DECISION DELEGATED TO DEVELOPMENT MANAGER

Application No: H21-0582-20 **Applicant:** Mr & Mrs Wykes
Proposal: Domestic workshop/domestic storage building
Location: 1 Pumping Station Cottages Station Road Tydd Gote
Terminal Date: 14th September 2020

PROPOSED GROUND
FLOOR PLAN 1:50

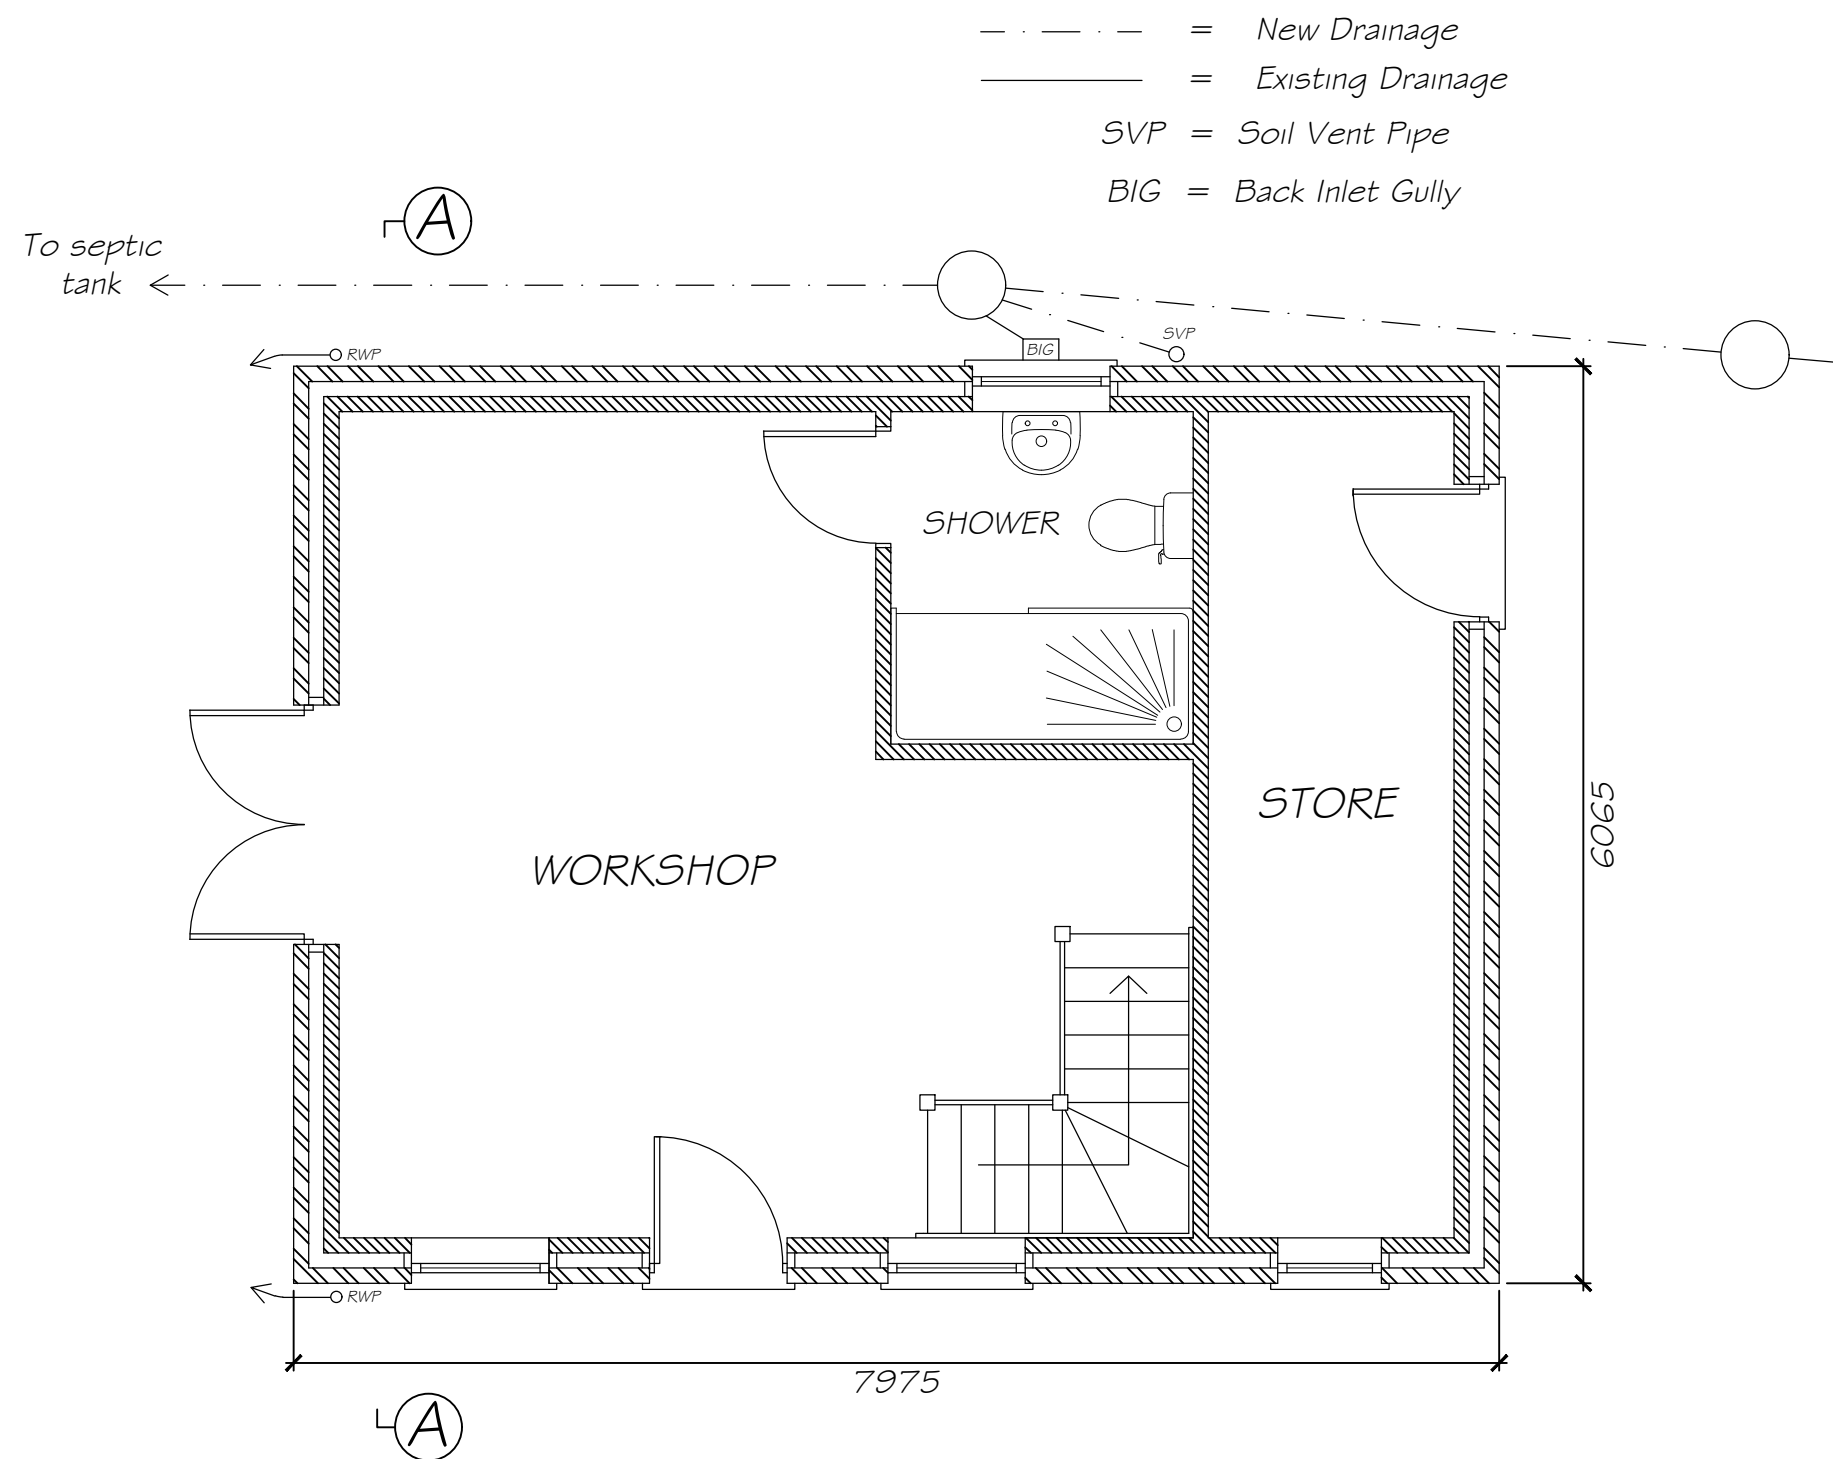
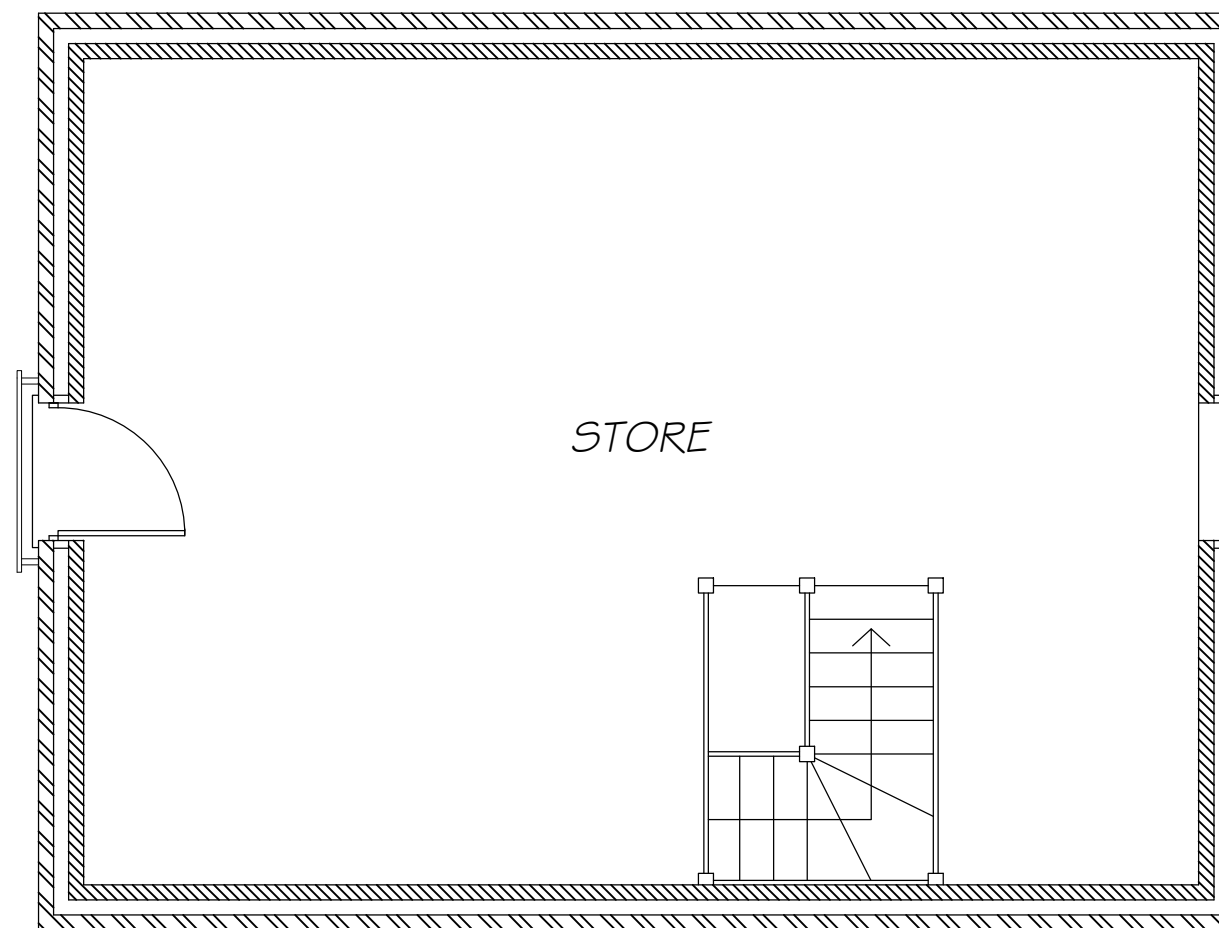
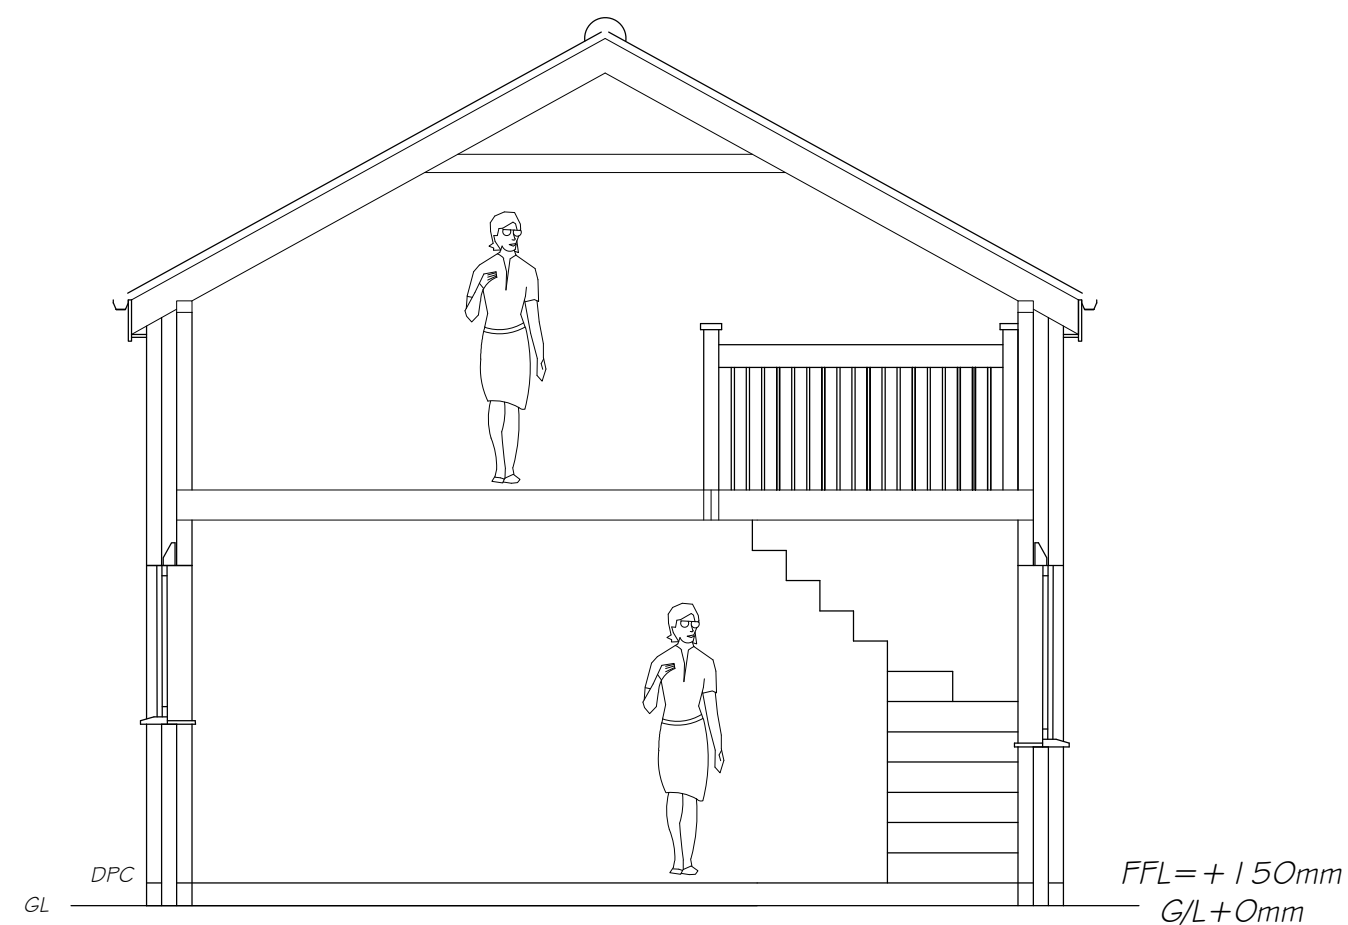
Internally, the building will have two storeys. Most of the ground floor level will be used for workshop in addition to shower room and storage room to the rear. A staircase will serve access to the loft space which will be used for further storage.

The facilities, amount of internal floorspace and ceiling height (2.10 metres) might be sufficient to create permanent residential accommodation within the outbuilding. However, the intended purposes per each room are clearly shown on the proposed floor plans. When granting permission subject to these plans, no residential but incidental use to the main property will be only granted for the development.
